Item No.	Report of the Head of Planning, Transportation and Regeneration		
Address	2 GATEHILL ROAD NORTHWOOD		
Development:	Erection of two storey side extension and two storey rear extension involving demolition of existing garage and installation of new AC units		
LBH Ref Nos:	10808/APP/2022/631

Drawing Nos:	8979 22 Rev. A (received on 27.04.2022) 8979 21 Rev. A (received on 28.04.2022) Noise Impact Assessment by Healthy Abode Acoustics Ref: HA/AE357/V1 8979 23 Rev. B (received on 30.05.2022) Daikin Air conditioning units brochure for models MXM-N / N8 / N9 by George's Industrial Services Ltd Design and Access and Planning Statement (dated February 2022) Arboricultural Impact Assessment Method Statement & Tree Protection Plan (to BS:5837 2012) dated 25h November 2021, Ref: TH 2412/C Daikin Air conditioning units brochure for models FTXA-A/B (W/S/T/B) / RXA-A/B by George's Industrial Services		
Date Plans Received:	25/02/2022	Date(s) of Amendment(s):	27/04/2022
Date Application Valid:	11/03/2022		30/05/2022
			26/05/2022
			25/02/2022
			28/04/2022
			26/04/2022

project	Proposed AC @ 2 Gatehill Road, Northwood HA6 3QD		
detail	Proposed Elevations		
drawn	mmh	checked	
date	Feb 22	status	Planning
a1 scale	a3 scale	rev	
as shown	8979 23	B

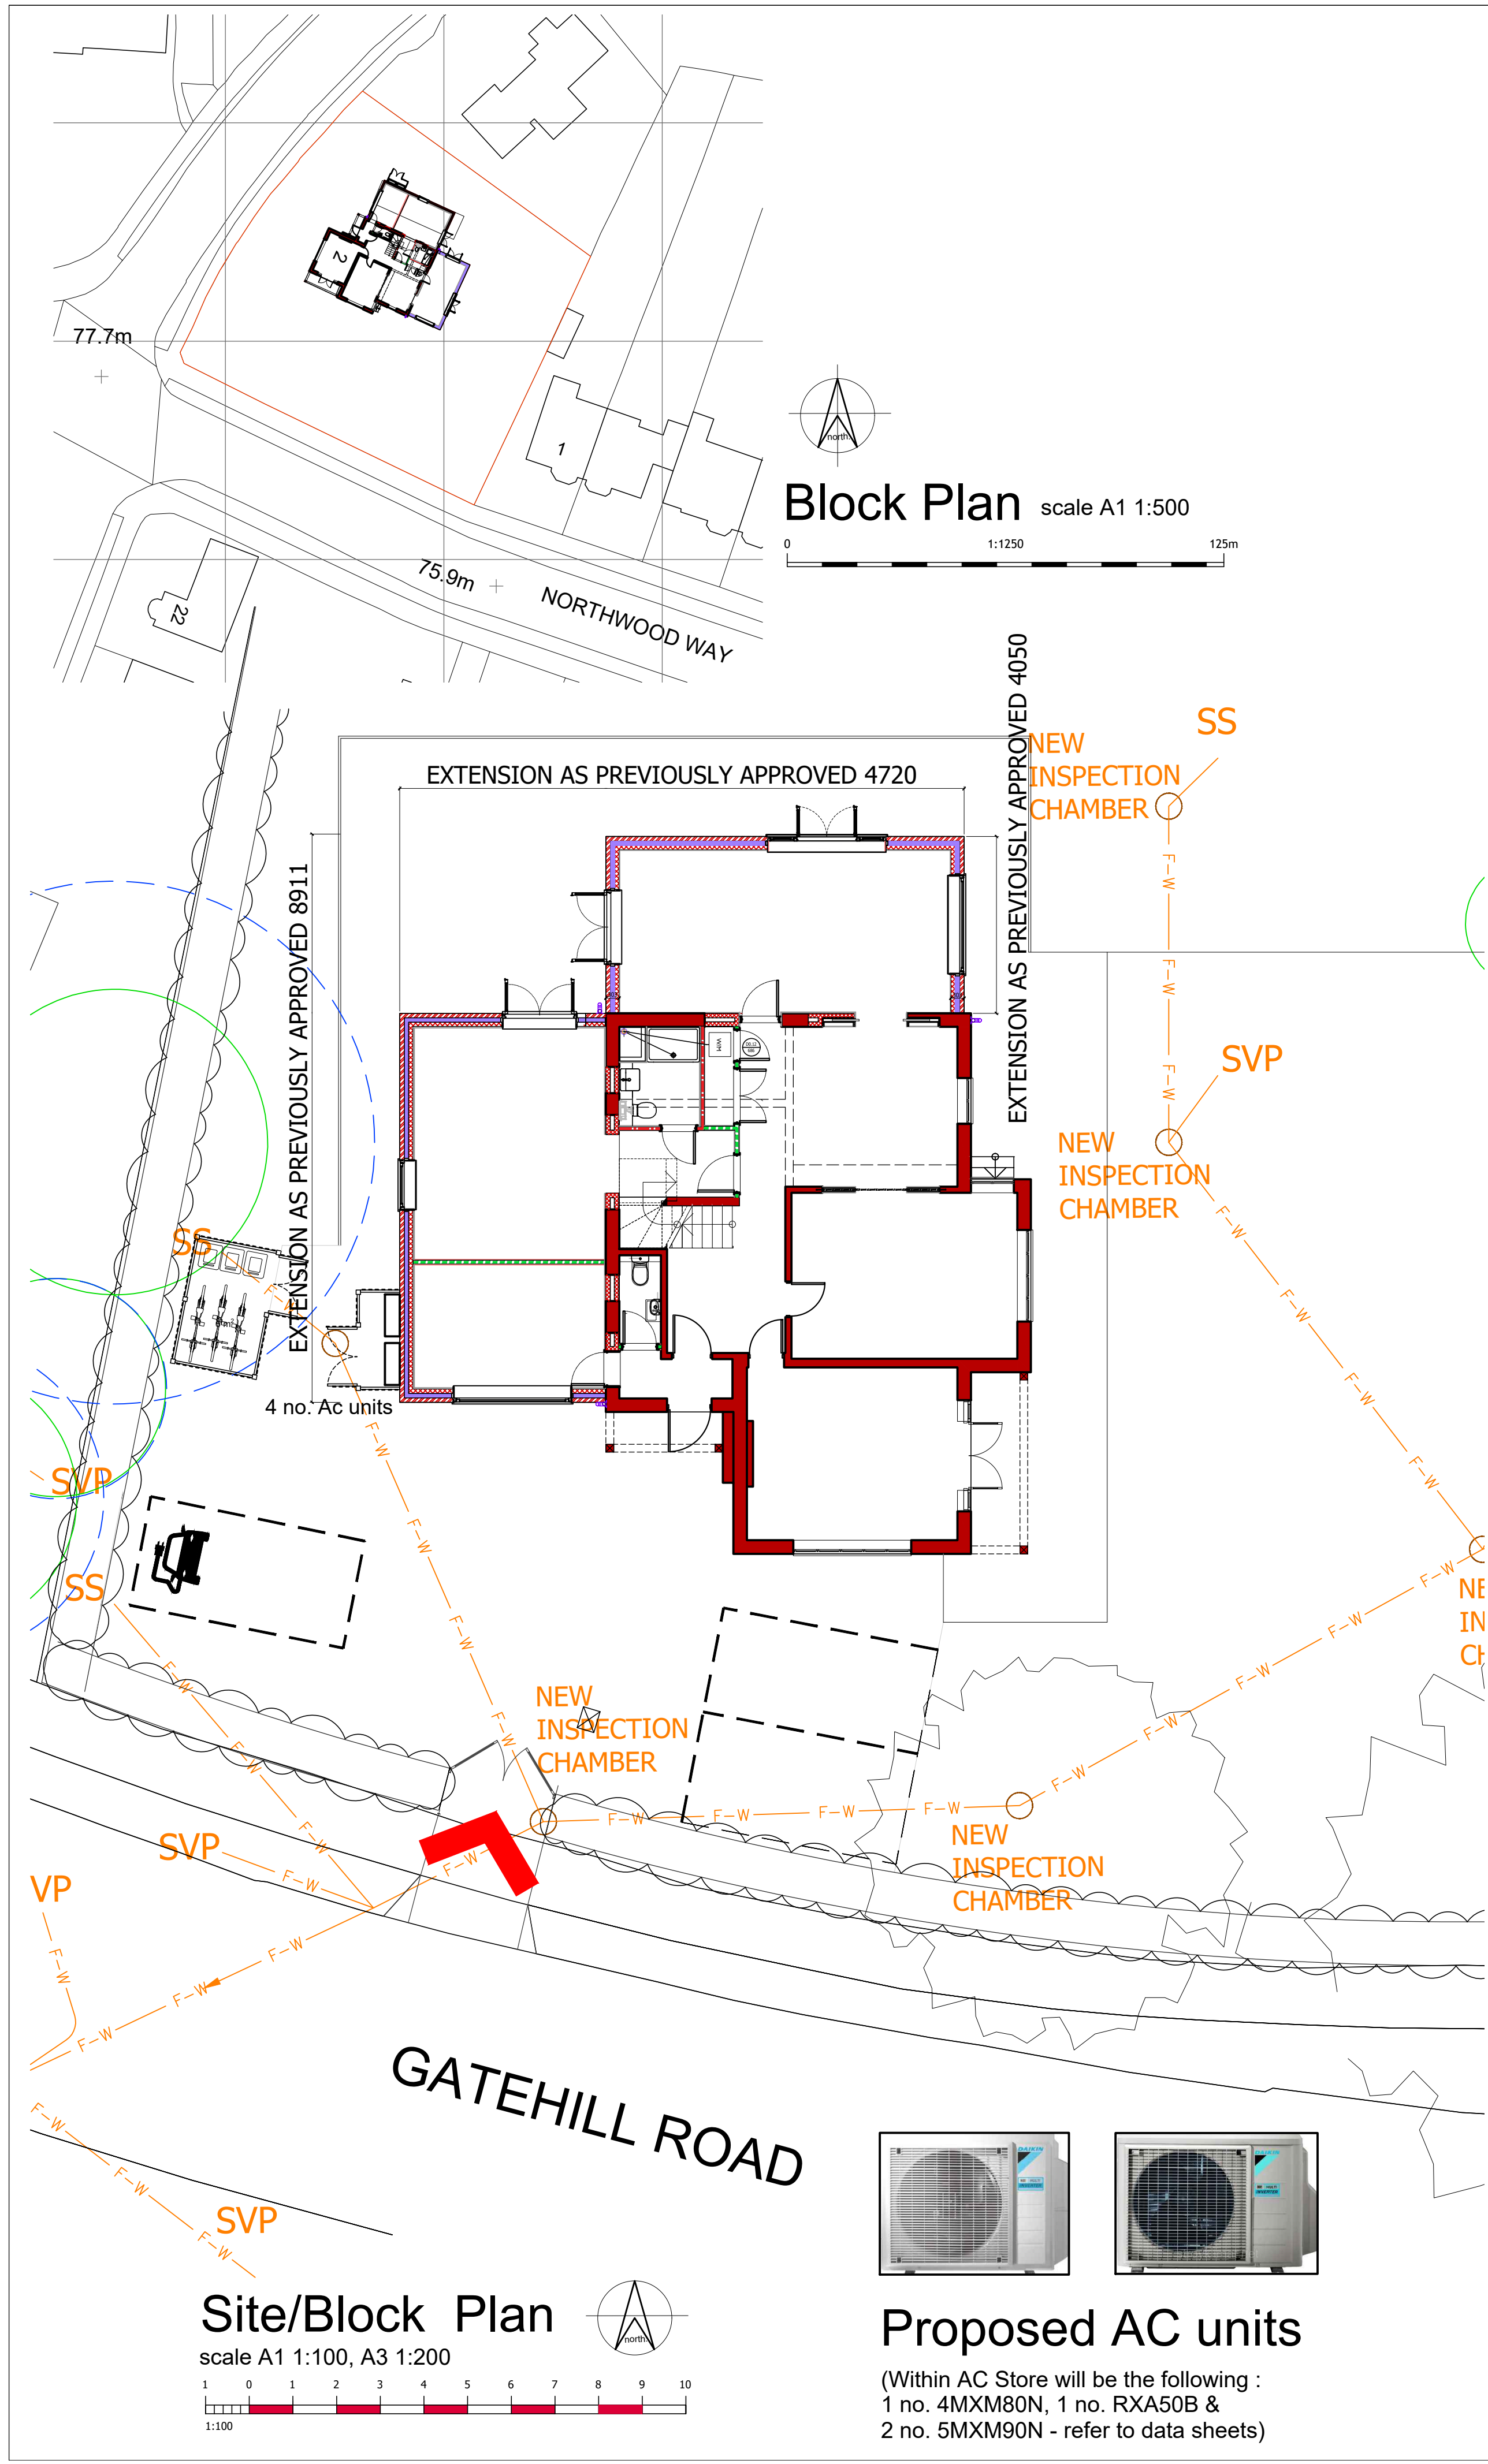
- The air conditioning units would be situated close to the boundary with No. 4 Gatehill Road.
- The noise from the continued operation of the proposed four air conditioning units (with an noise level of 64 decibels) will be intrusive and provide on-going noise pollution which will have a significant detrimental impact on the neighbouring property at No.4.

- An excessive number of air conditioning units are being proposed for a house of this size.
- The air conditioning units should be placed on the side of the property, adjacent to the start of Northwood Way.

The proposed four air conditioning units would be located along the north-eastern elevation of the host dwelling. Due to its position and relatively minor size, it is considered that the proposed enclosed A/C units would not detract from the character and appearance of the host dwelling or the surrounding Gatehill Estate ASLC.

As previously stated, a noise impact assessment was submitted by the applicant during the course of this application. The Council's Noise Officer has reviewed the report and has raised no objection, subject to a condition requiring the noise levels of the A/C units to be below 35 dB(A) measured 1 metre outside of any window of any dwelling. The Noise Officer also recommended that a purpose built acoustic louvred design enclosure for the A/C units such as that referenced in the report, rather than the hardwood design presented in the drawing and photo submissions. Again, full details of the purpose built enclosure would be secured by condition, in the event of an approval.

The objection received about possible noise issues has been duly noted. However, subject to the above conditions, it is considered that the noise implications of the proposed air conditioning units would not result in unreasonable harm to the residential amenities of neighbouring occupiers, in terms of noise and disturbance. It is worth noting that there is separate legislation in place to control noise nuisances.

AC Store Plans & Elevations
scale A1 1:50, A3 1:100

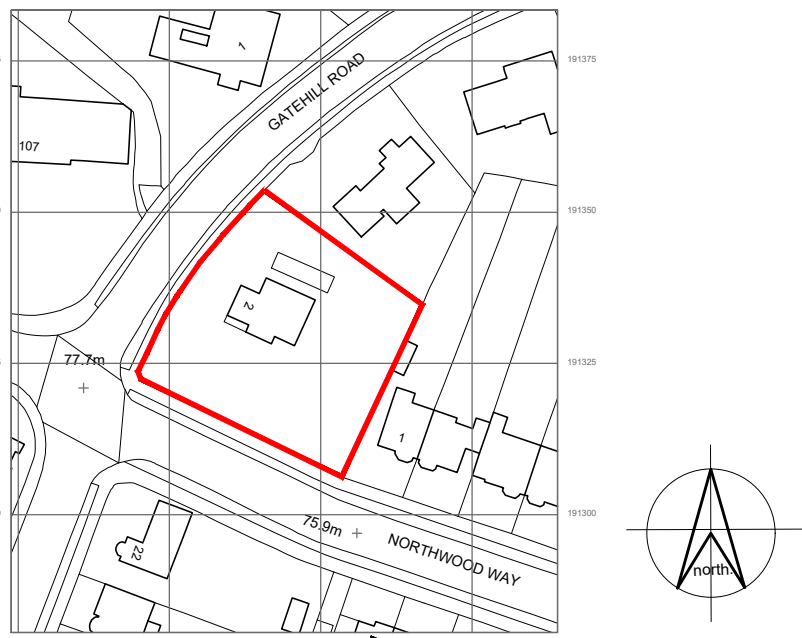
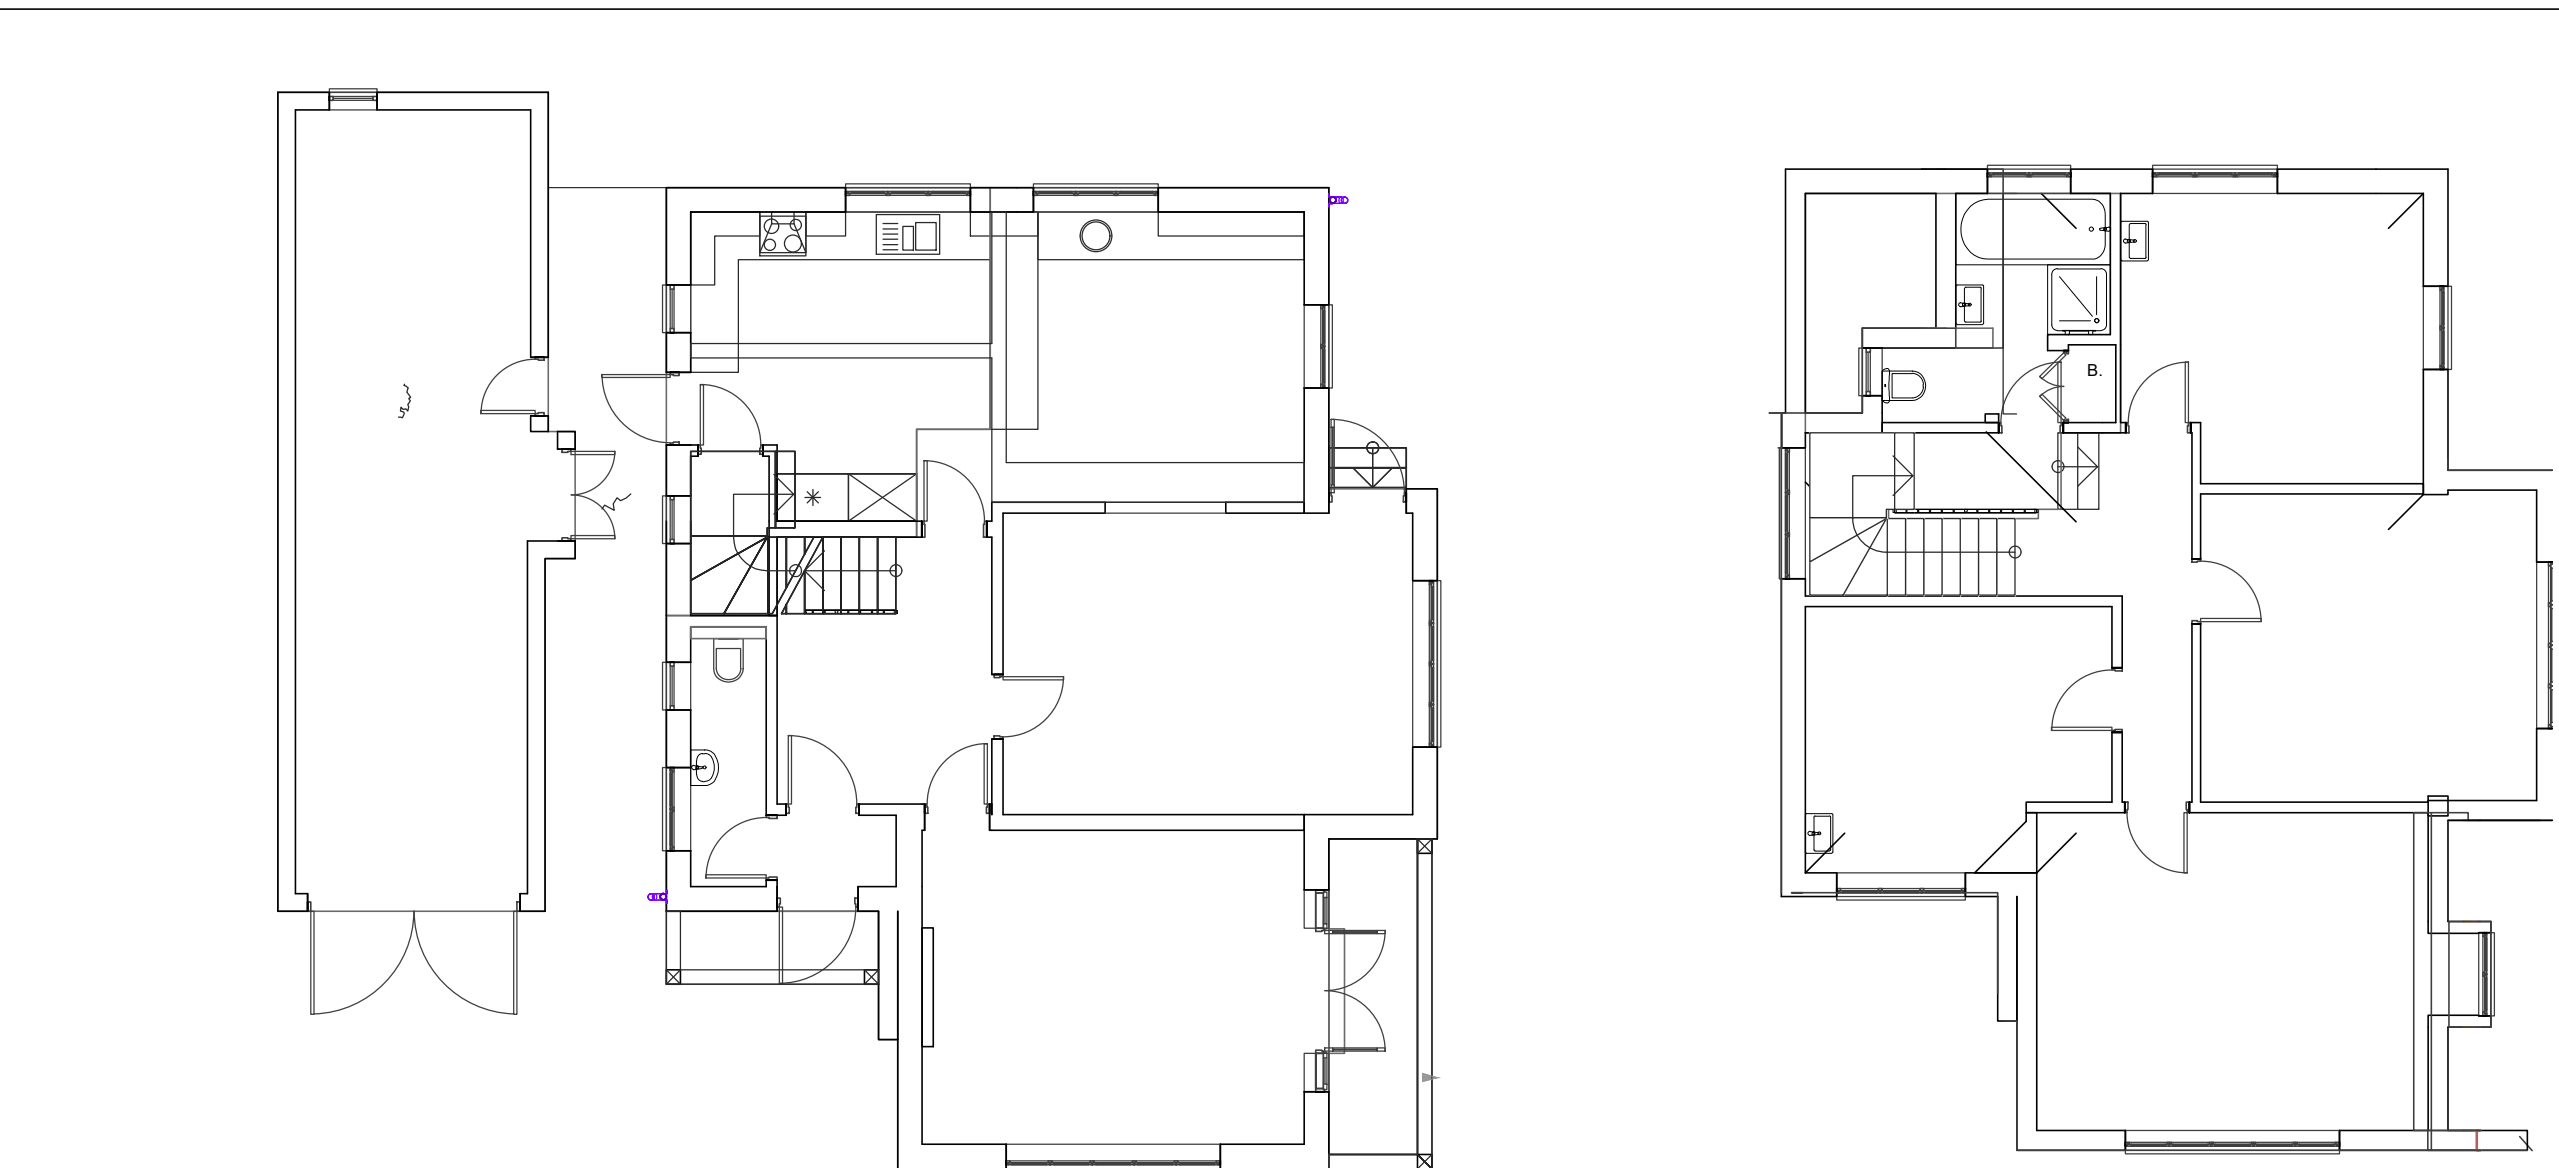
Gatehill Residents Association: "The Application shows the installation of Air Conditioning Units one of which has a waste air discharge pointing directly at the garden of number 4 Gatehill Road. This discharge is potentially a danger to the residents of No.4 and in any side-effects of the noxious discharges will, obviously, be more of an issue for children. The current occupant of No.4 has small children and they would be expected to play in the garden in Summer at the very time when the Air Conditioning may be used to its maximum. This will put them at risk. Are they expected to not play or can the Air

Conditioning unit be removed? We would ask that any approval for the Application includes a condition that to allow current and future owners of No.4 Gatehill Road and especially their children be allowed to use their garden safely, no Air Conditioning units be placed on the wall facing No.4 Gatehill Road."

The noise assessment report uses methods of assessing noise impact from the installation of plant and equipment having regard to the BS4142 which refers to 'commercial and industrial sound' It also refers to guidance for noise levels inside residential buildings BS8233. As can be seen in this situation the noise change method (BS4142) tends towards a much more onerous design target, because the existing background noise level is very low. A value of LA90 night of 22dB might be found in a rural environment remote from strategic transport infrastructure, however it would appear that well screened suburban areas can experience similarly low levels. The consequence may be a design that compromises visual appearance in favour of acoustic performance, for example the installation of a purpose built acoustic louvred design system such as that referenced in the report rather than the hardwood design presented in the drawing and photo submissions.

The proposed AC units would be located along the north side elevation of the approved side addition. The timber panel enclosure would limit the impact of the modern units on the character and appearance of the ASLC, however they would harm the building itself.

PLANNING OFFICER RESPONSE: During the course of this application a noise impact assessment was submitted to demonstrate that the resultant sound pressure level of the proposed A/C units. The Council's Noise Officer has reviewed the report and has raised no objection to the proposal, subject to conditions. With respect to concerns about odour or air quality, it is of the Noise Officer's view that the proposal is for an air conditioning system that pushes fresh air into the dwelling, which then leaks out naturally, not a system that is extracting fumes from say a kitchen. No other evidence from the representations received has been submitted to demonstrate otherwise.

'For the lifetime of the development hereby permitted the rating level of noise caused by the operation of plant, machinery or equipment shall be below 35 dB(A) measured 1 metre outside of any window of any dwelling, or similarly noise sensitive premises, determined in accordance with the procedures set out in British Standard BS4142:2014.'

RESPONSE: In line with the Noise Officer's recommendations, Condition 3 has been retained as proposed by planning officers. This requires the appearance of the air conditioning enclosure to be carried out so that it's external appearance matches the approved drawing. Also, the wording of Condition 5 has been revised to reflect the recommended wording suggested by Noise Officer to ensure potential noise impacts are mitigated.
